The Lodge  
1 Armstrong Road  
Littlemore  
OXFORD  
OX4 4XT

19 October 2022

**21/00517/F**

**Creation of a motocross track and soft landscaping scheme and the change of use of agricultural land to hold moto-cross events including set-up, take down and private practice sessions, with associated camping site, for up to 65 days per year and agricultural grazing (retrospective).**

Figure 4: Off-site Habitat

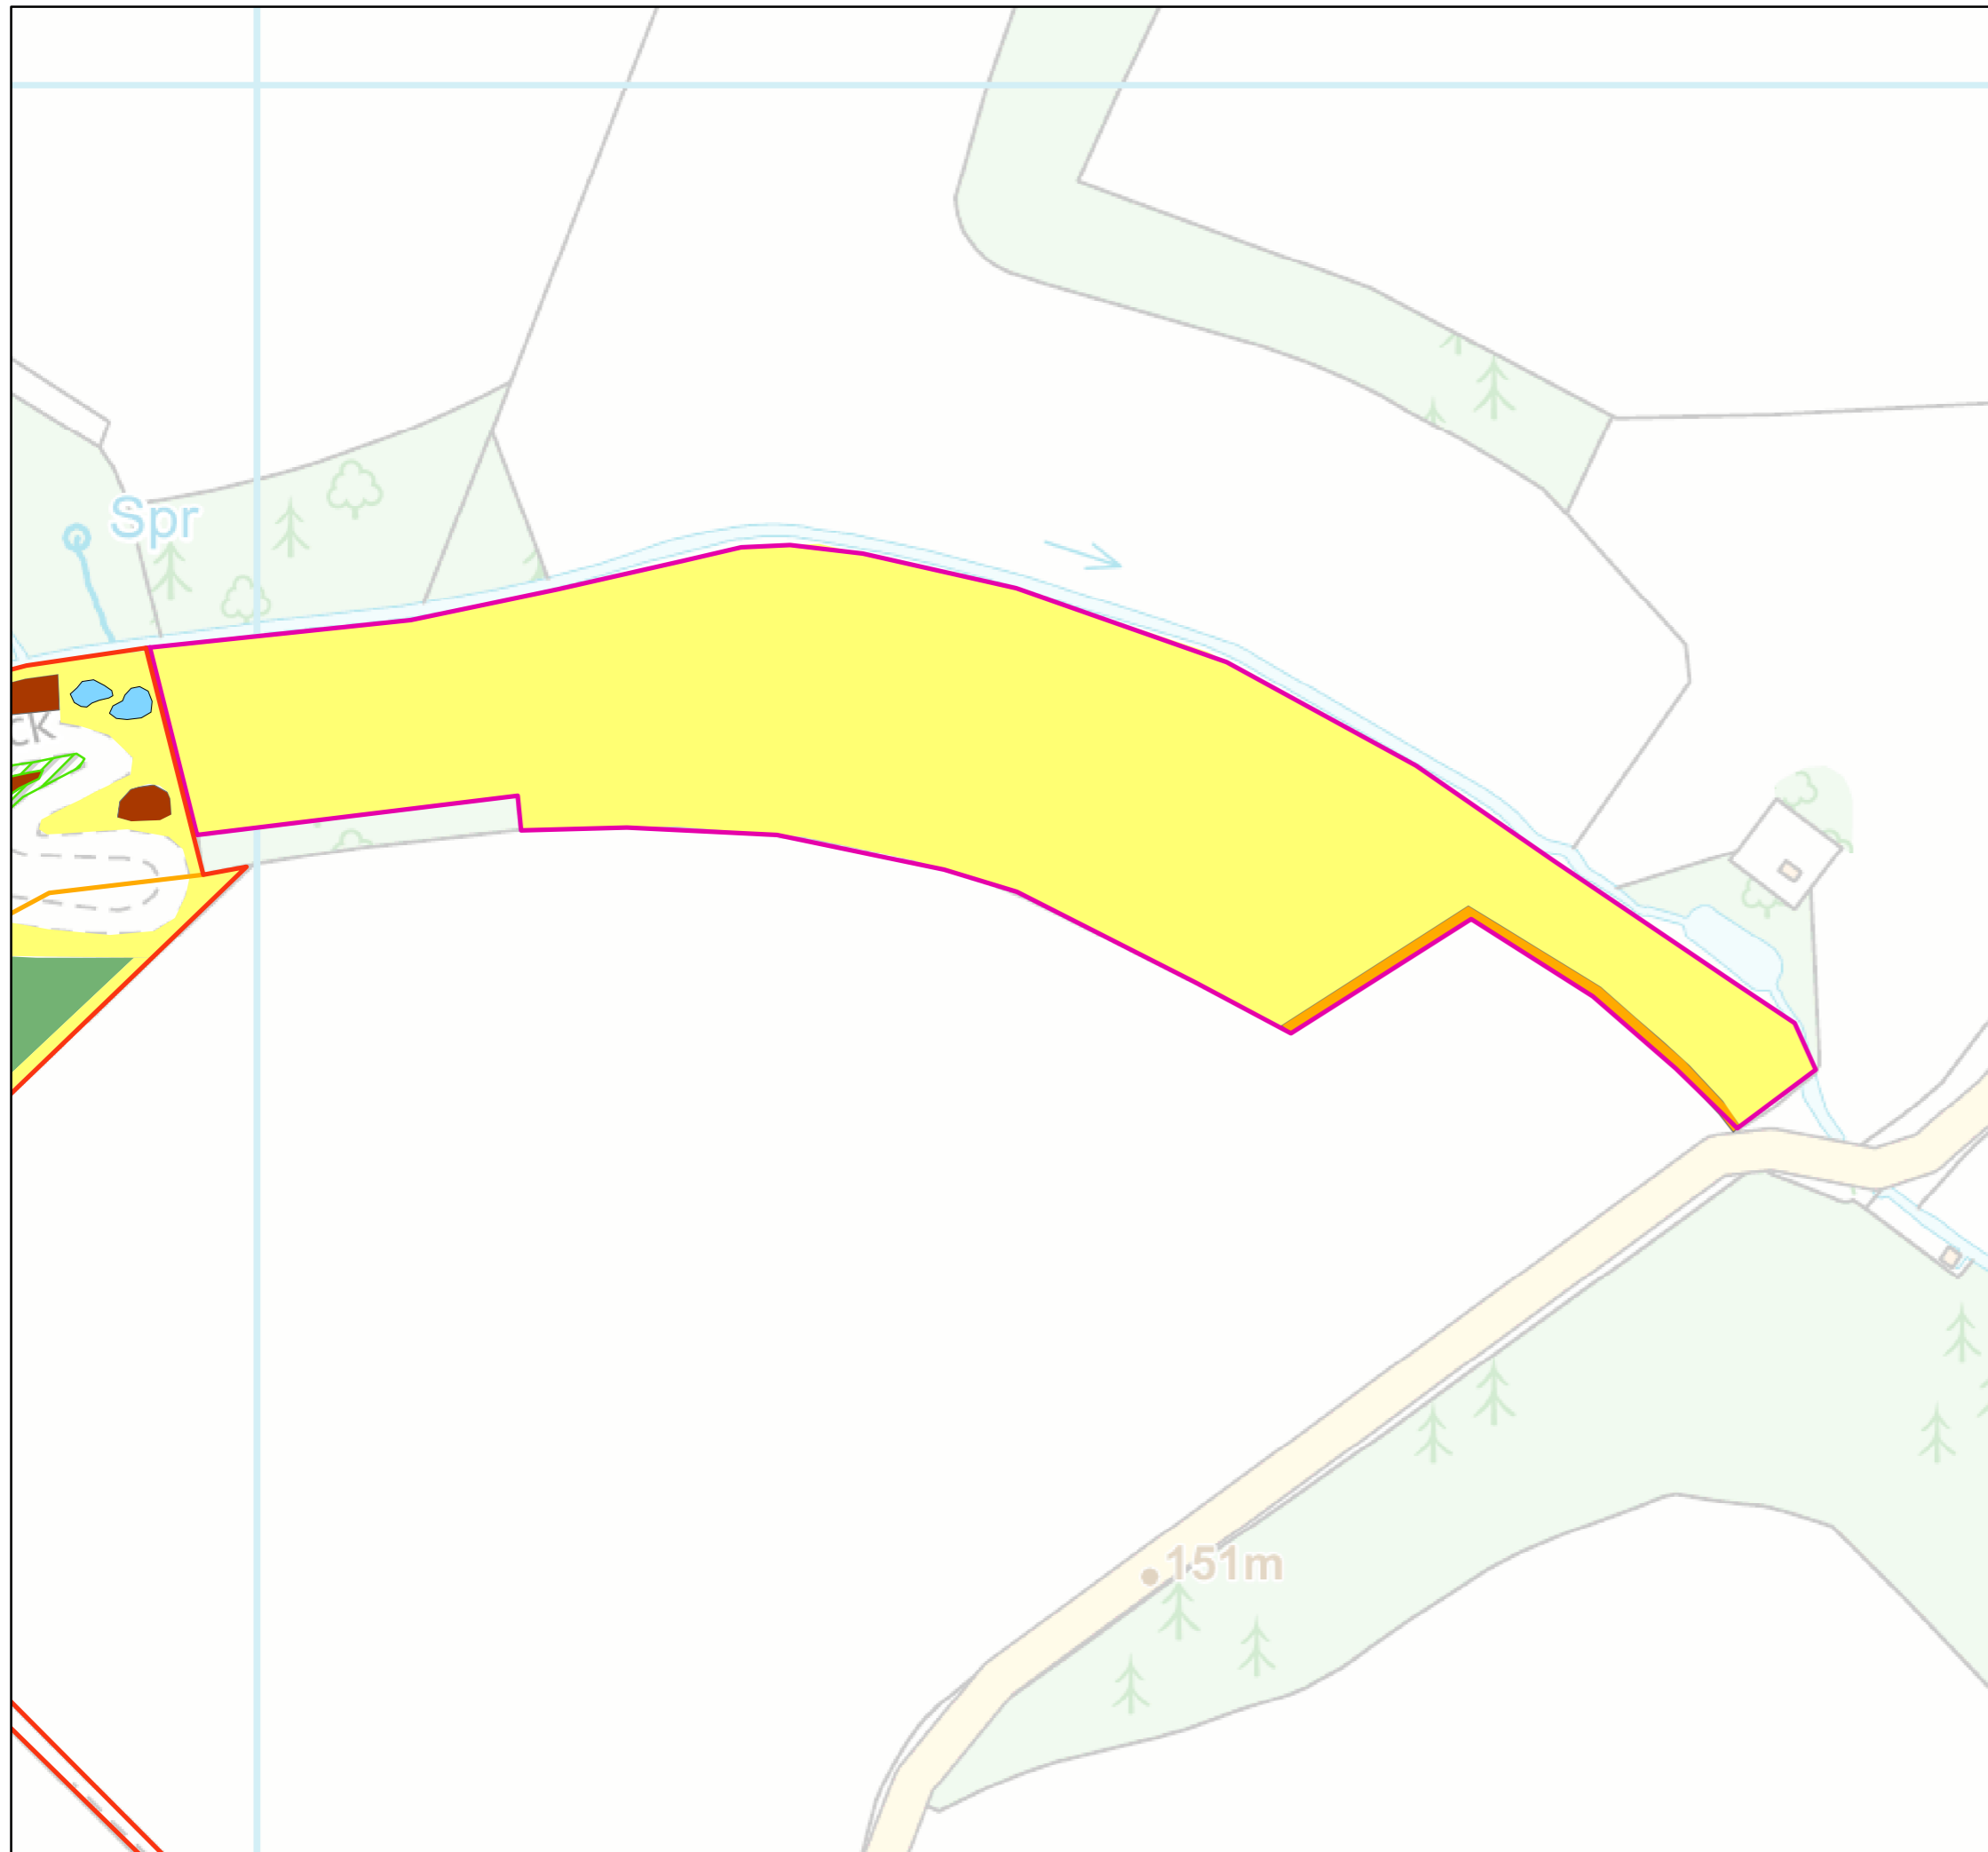
We welcome the submission of the revised net gain metric spreadsheet (dated 9/9/2022), the ecological enhancement measures (dated September 2022) and the document labelled Figure 4. Off-site Habitat Enhancement Map. **We ask that conditions are used to ensure that, in the event the authority are minded to approve the application, the measures set out in these documents are implemented and maintained.**
